STERLING RANCH FILING 4

STREET IMPROVEMENT PLAN

NOVEMBER 2022

FILE NO. SF-22-030

PENNYDALE DRIVE
STA 10+40.00 TO 16+50.00

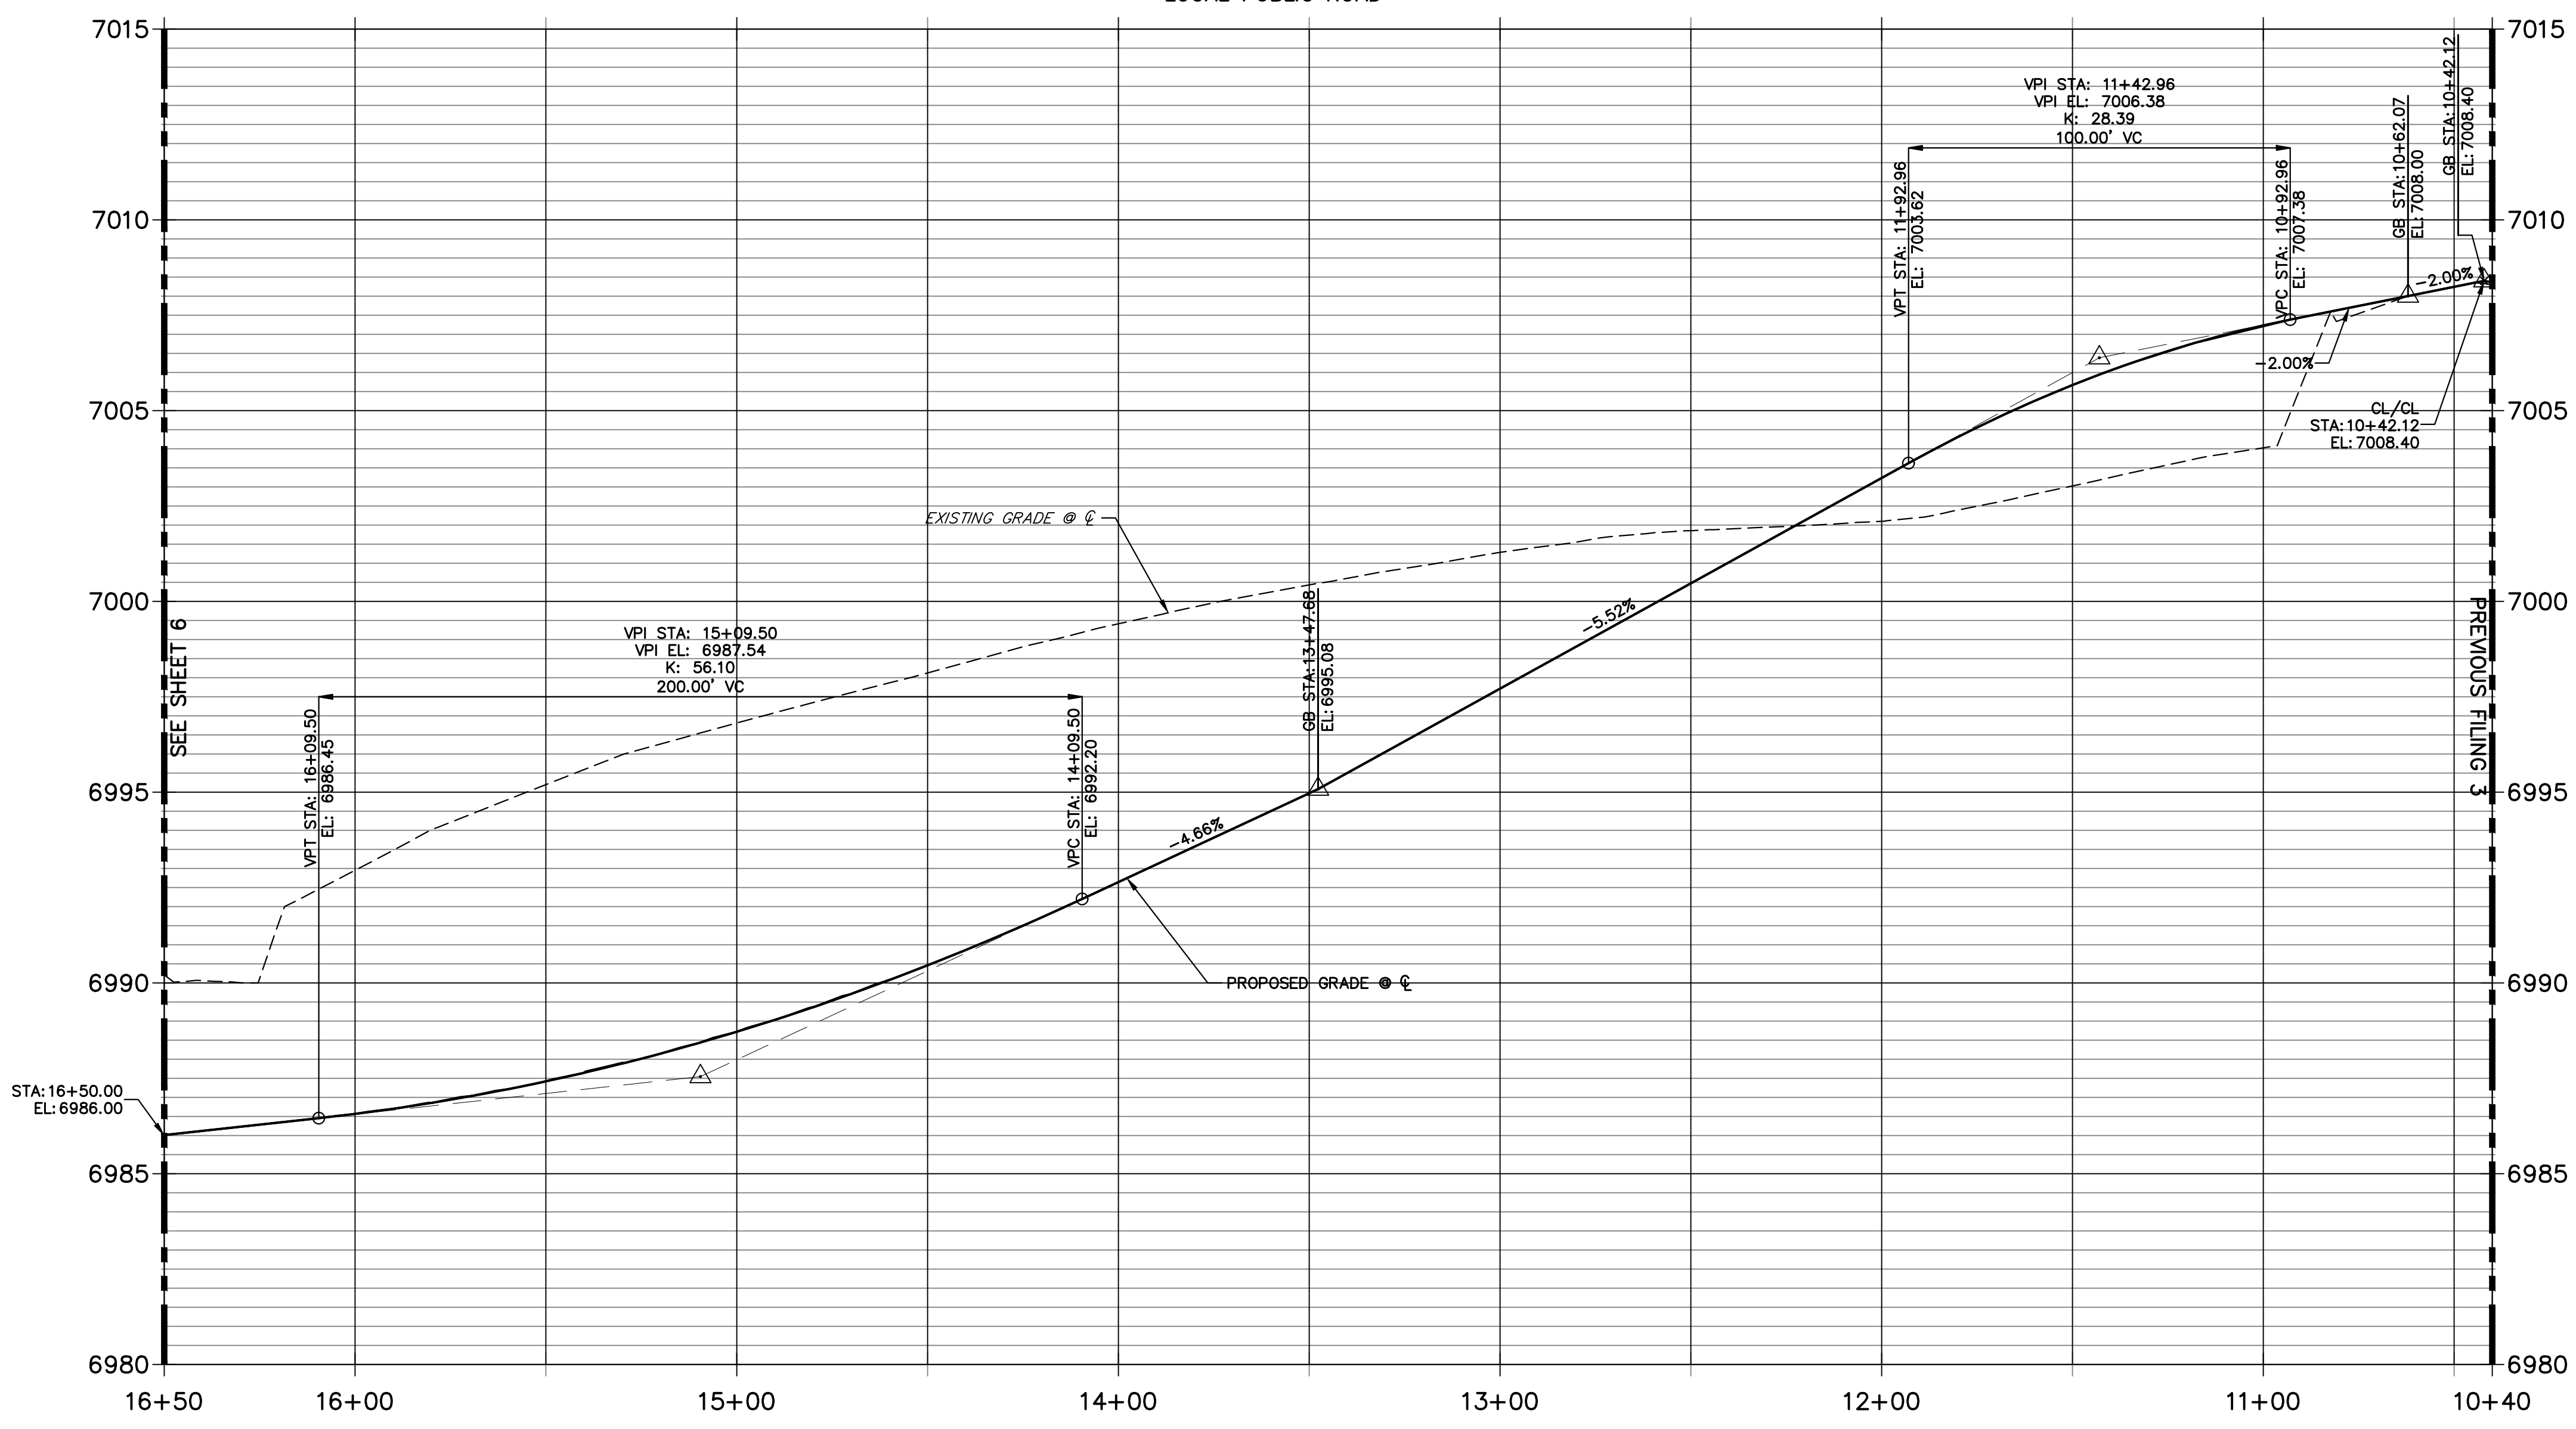
Replace point labels
JR Response: Replaced

Label lot numbers on all sheets
JR Response: Labeled
